Re: DISABILITY ACCESS REPORT

Project: Pymble Ladie's College Masterplan Phase 2
Address: Avon Rd, Pymble
Stage: Development Application Stage

DISABILITY ACCESS REPORT

Pymble Ladie's College Masterplan Phase 2
Development Application Stage

01 SECTION
Aquatic + Fitness Centre
Scale 1 : 200

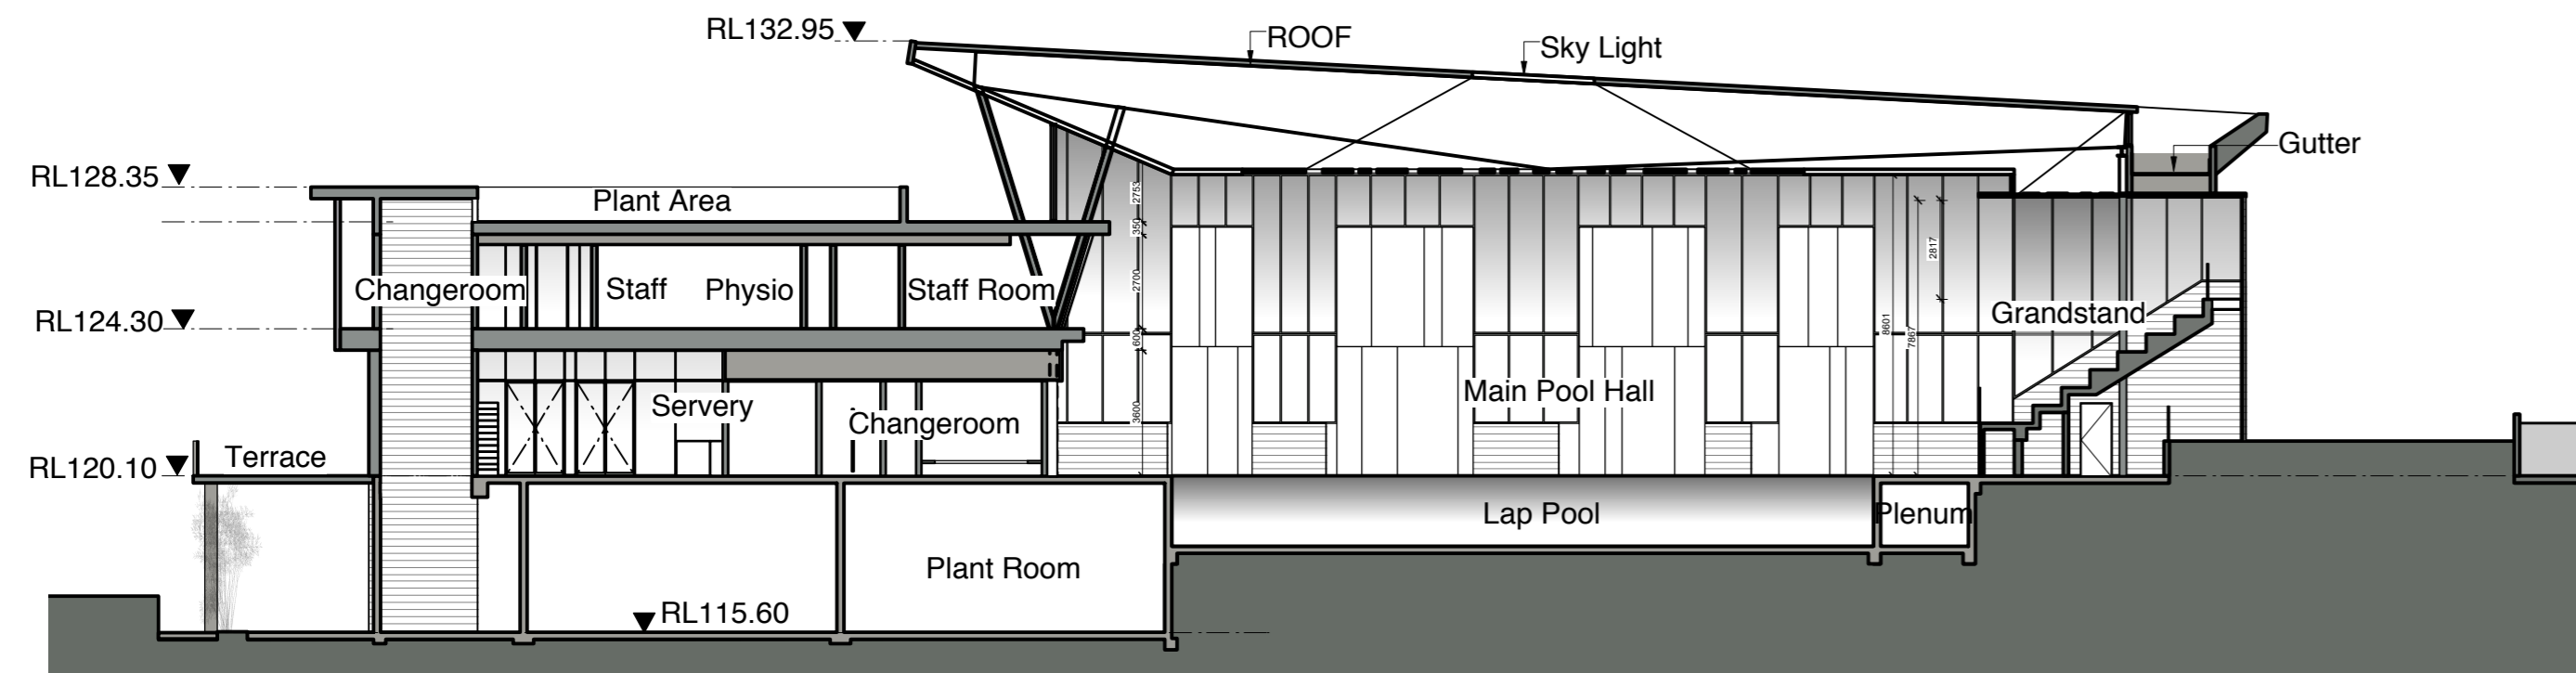
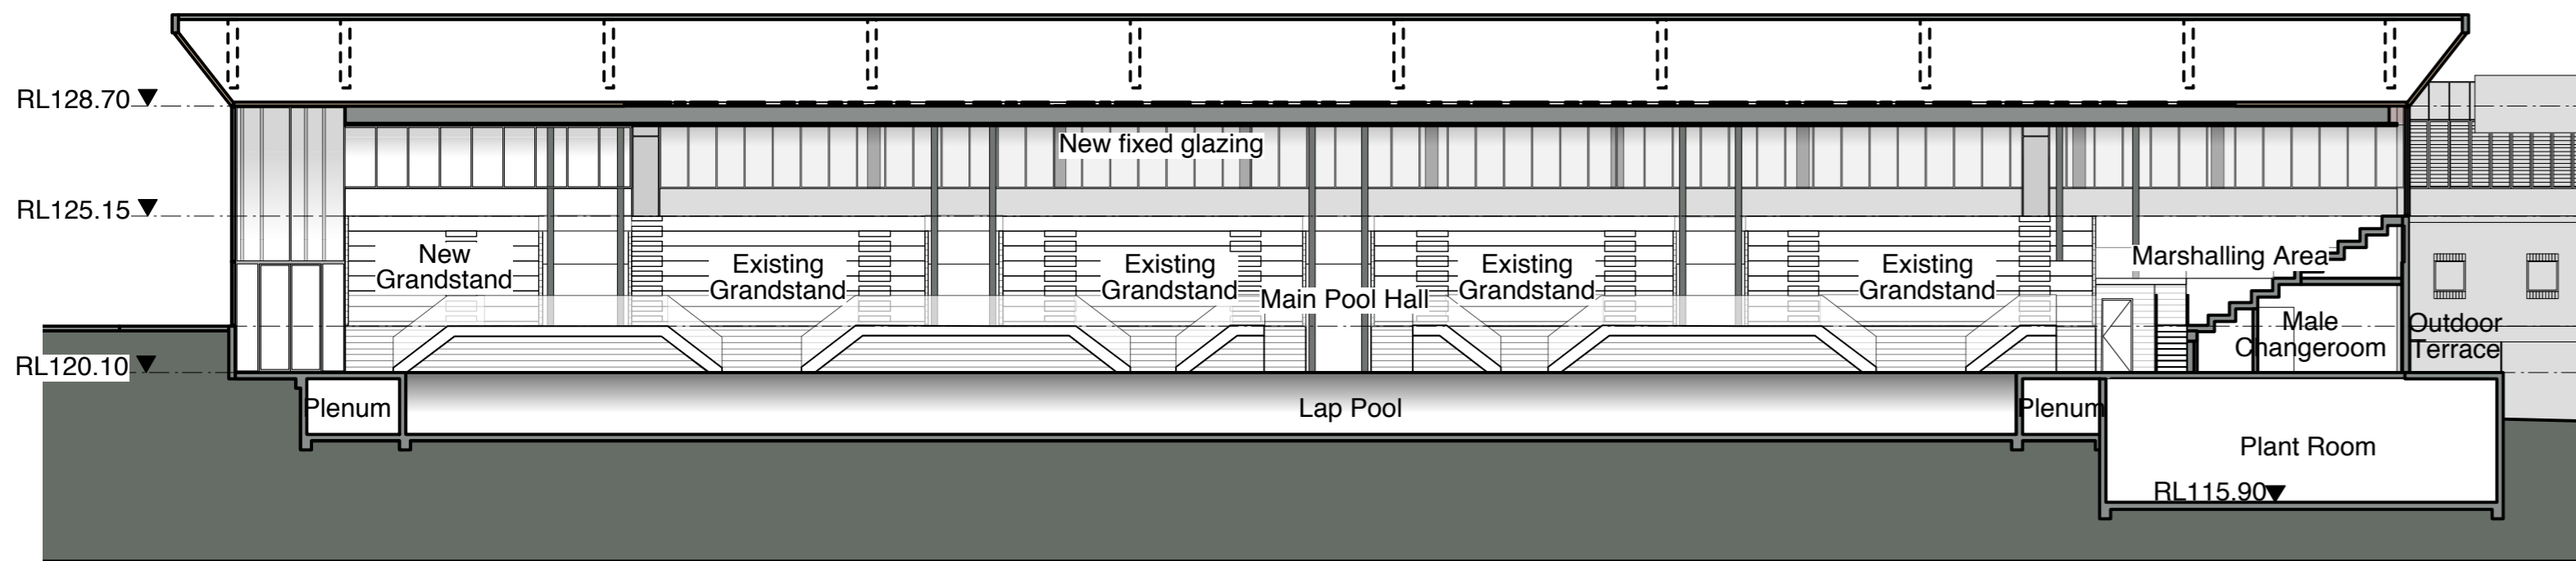
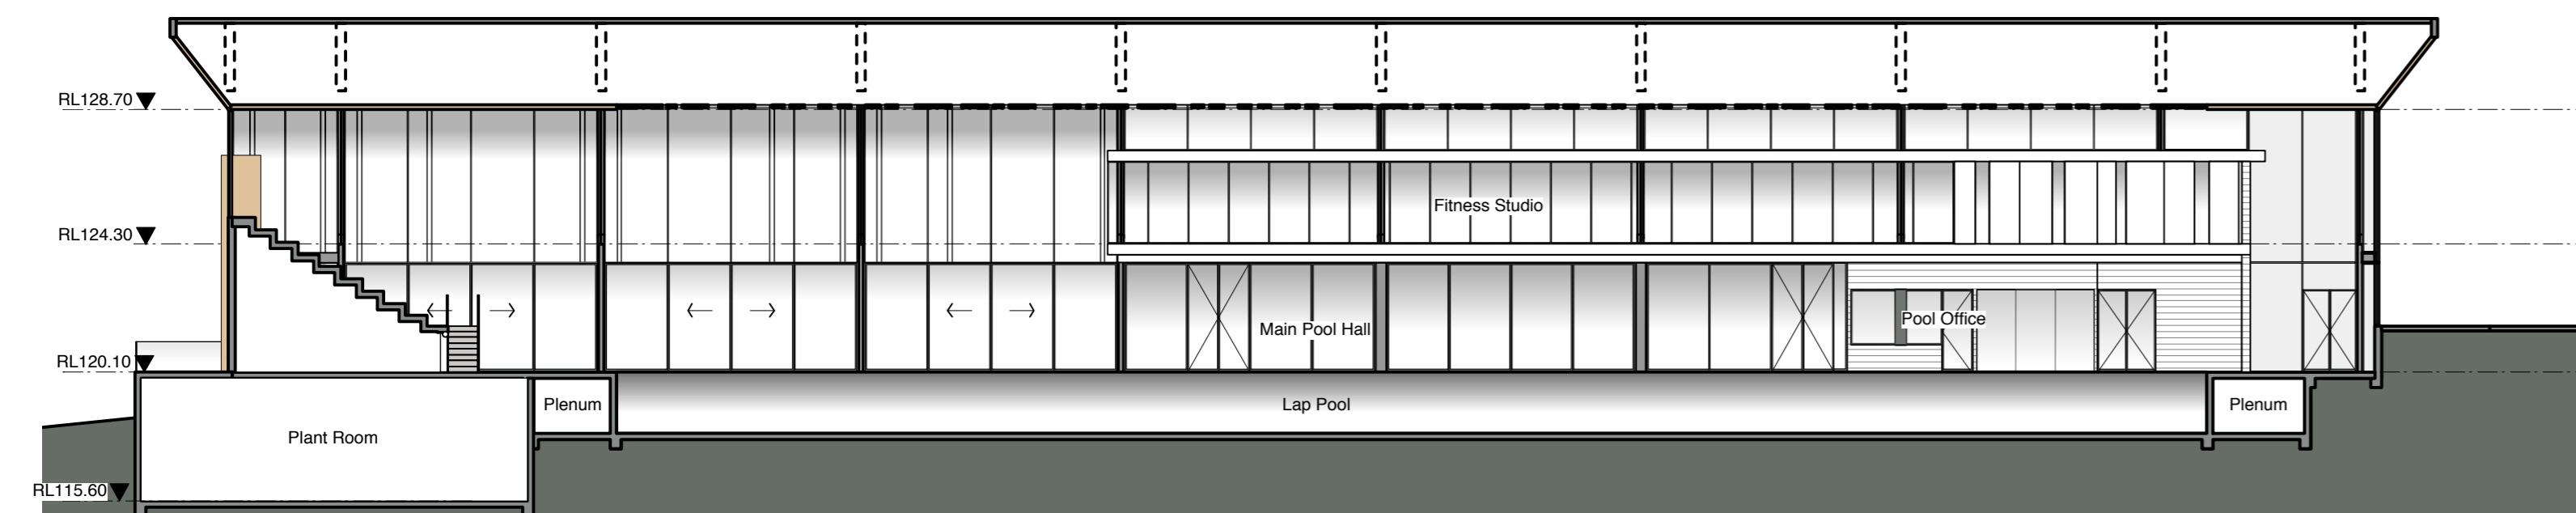
Clause	Access Requirement	Comments
		<p>have a clear width of at least 1000mm.</p> <p>There are also stairs leading up to the grand stand tiered seating which require compliant handrails, stair nosing and tactile indicators.</p> <p><u>Recommended Action</u></p> <ol style="list-style-type: none"> 1. Stairs require Clause 11, AS1428 compliant handrails and TGSIs. 2. Stairs require contrast strips to edge on stair nosings 50-75mm deep (30% contrast) to comply with AS1428.1 (f) and (g). <p>External Ramps</p> <p>Ramp access has been indicated in the following areas:</p> <ol style="list-style-type: none"> 1. Adjacent to Jeanette Buckham PE Centre to enter the aquatic centre. 2. Between aquatic centre level and down to Mollie Dive Field. <p>NB. As an interim measure, until the dining facility is constructed, a new 1:14 gradient ramp will be provided from the paved forecourt to Aquatic forecourt level. This provides an accessible pathway to the nominated accessible car space/ designated drop off area.</p> <p><u>Recommended Action</u></p> <p>Provide ramps to comply with Clause 10 (AS1428.1-2009).</p> <p>Lift</p> <p>There is one passenger lift, which provides access to all levels in the aquatic centre and fitness building. Lift Car dimensions is 1400mm by 1600mm.</p> <p><u>Recommended Action</u></p> <p>Further assessment at Construction Certificate stage is required to ensure compliance with relevant clauses of AS1735.12.</p> <p>Floor or ground surfaces</p> <p><u>Recommended Action</u></p>

01 LOWER LEVEL
Site Plan
Scale 1 : 500

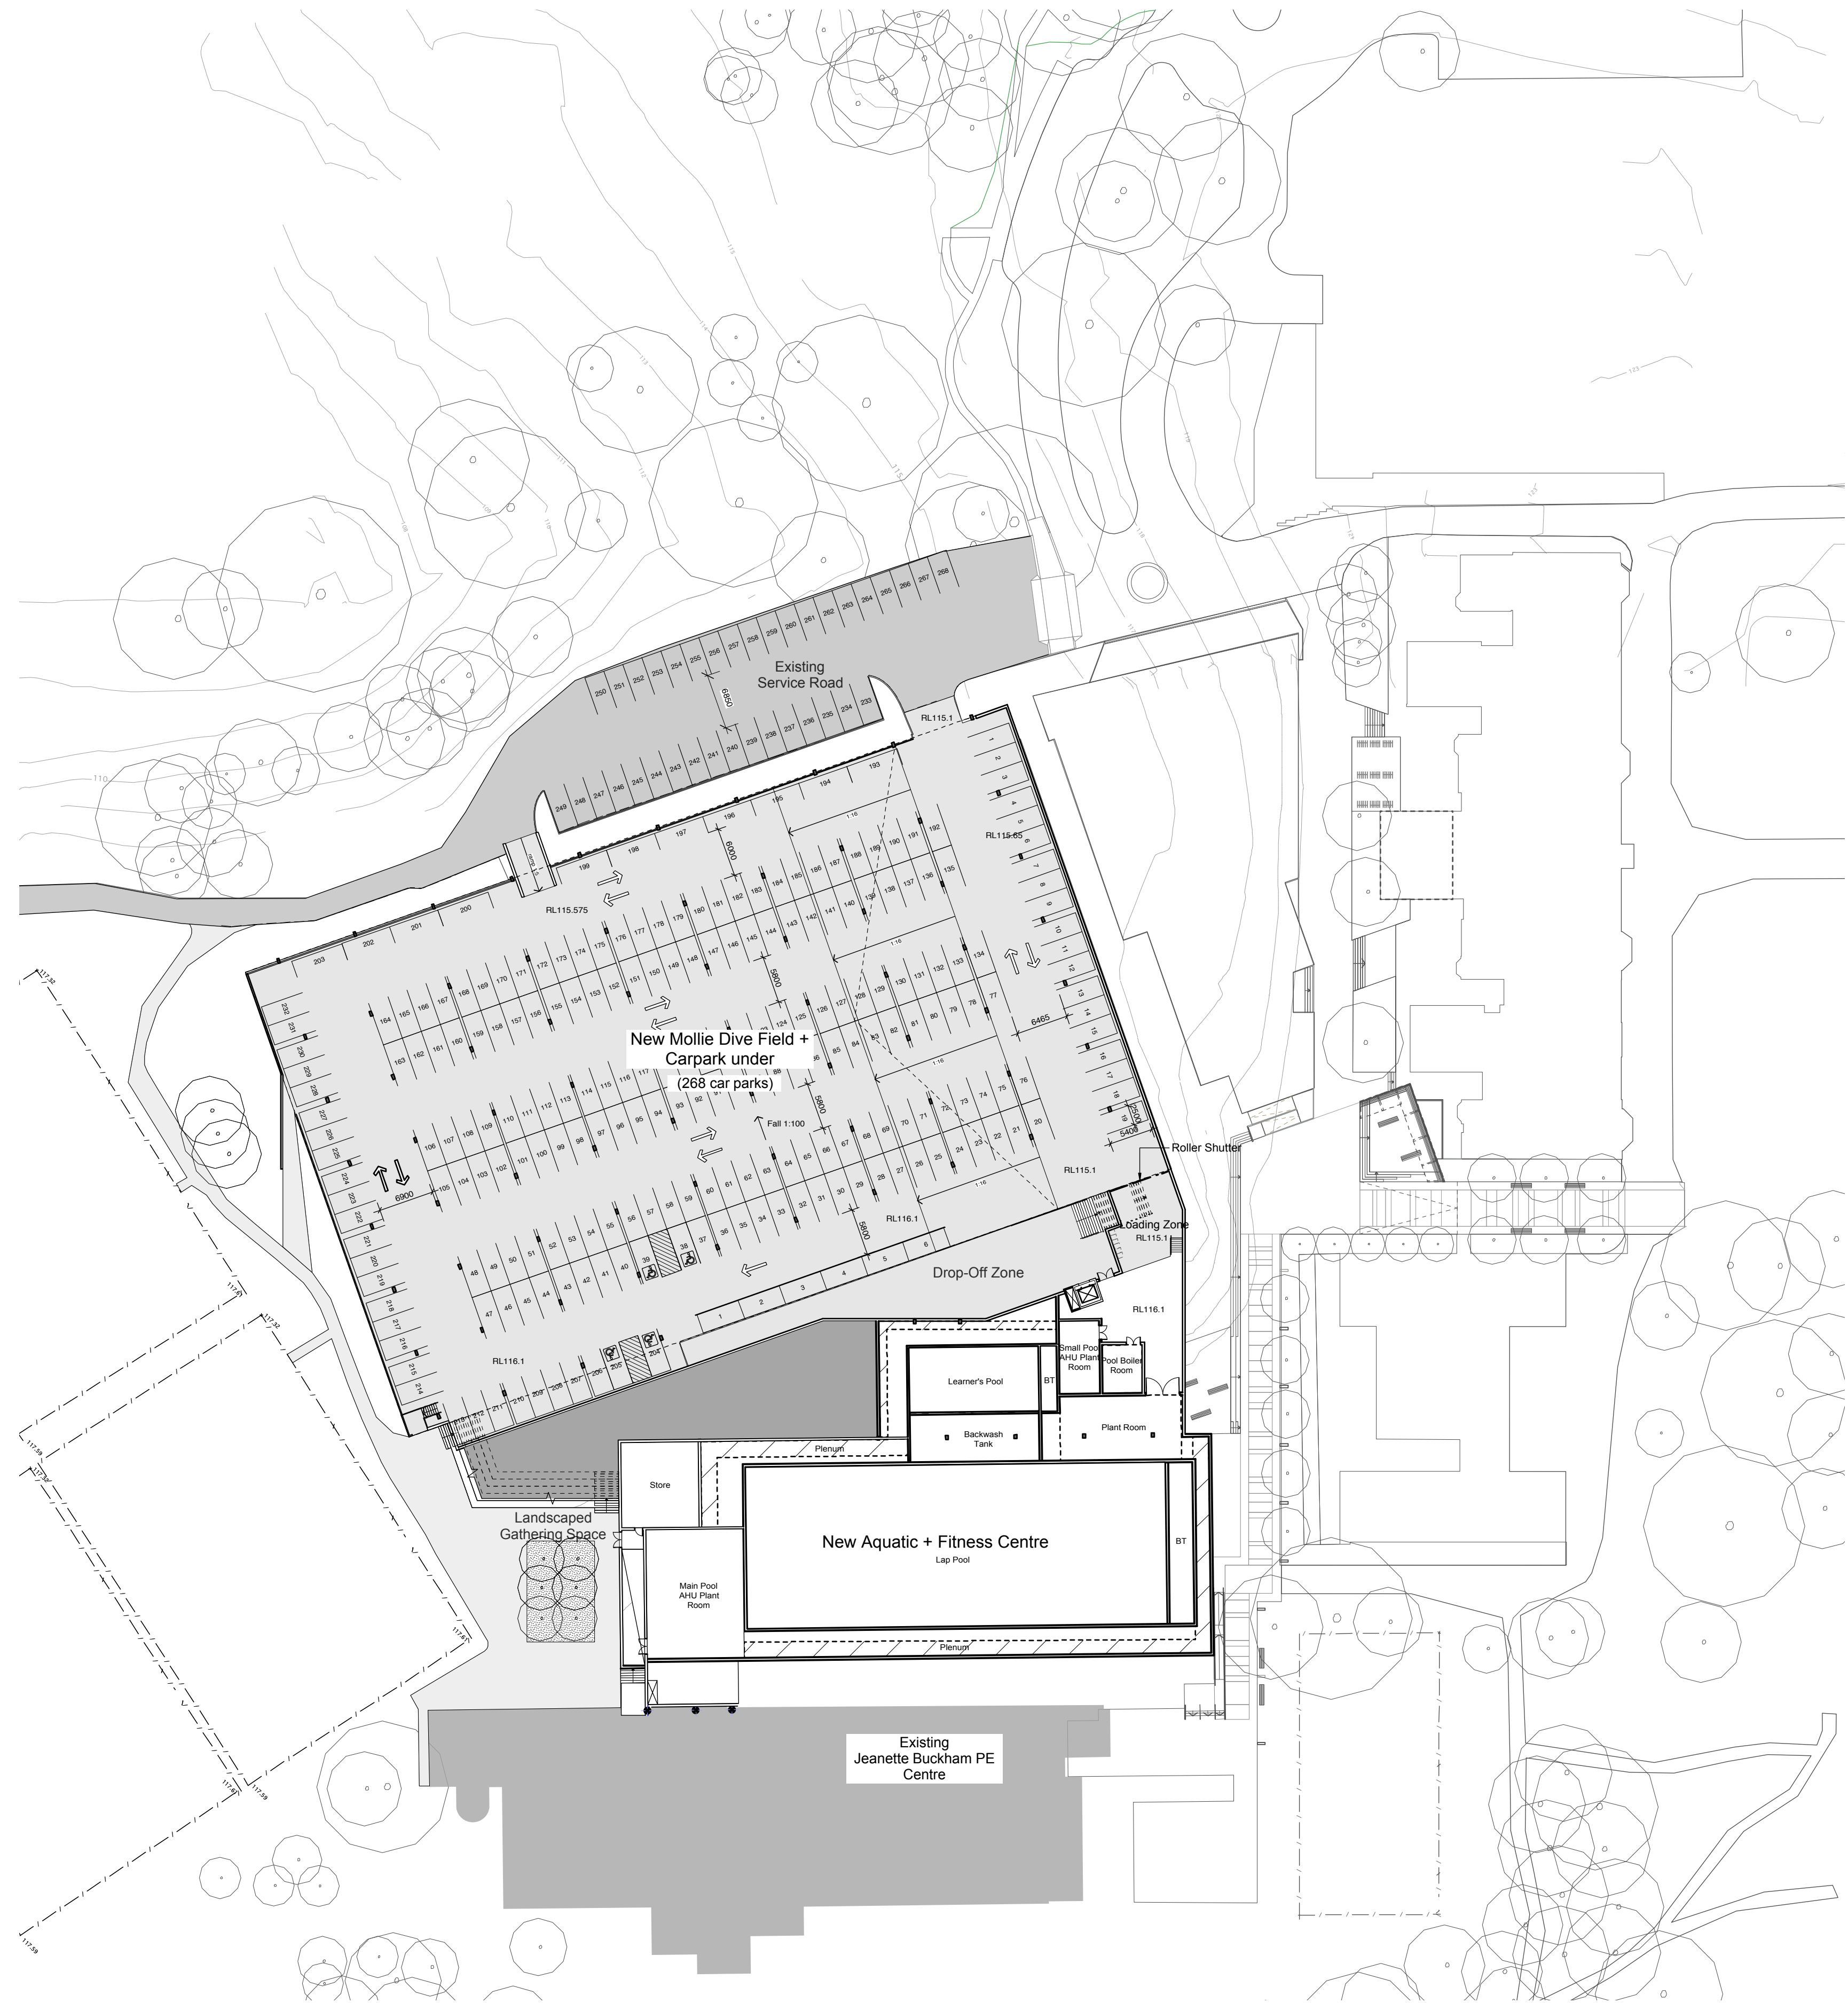
D3.2	Access to buildings	
	<p>(a) An accessway must be provided to a building required to be accessible</p> <p>–</p>	<p><i>There are accessible pathways indicated on lower floor drawings and</i></p>
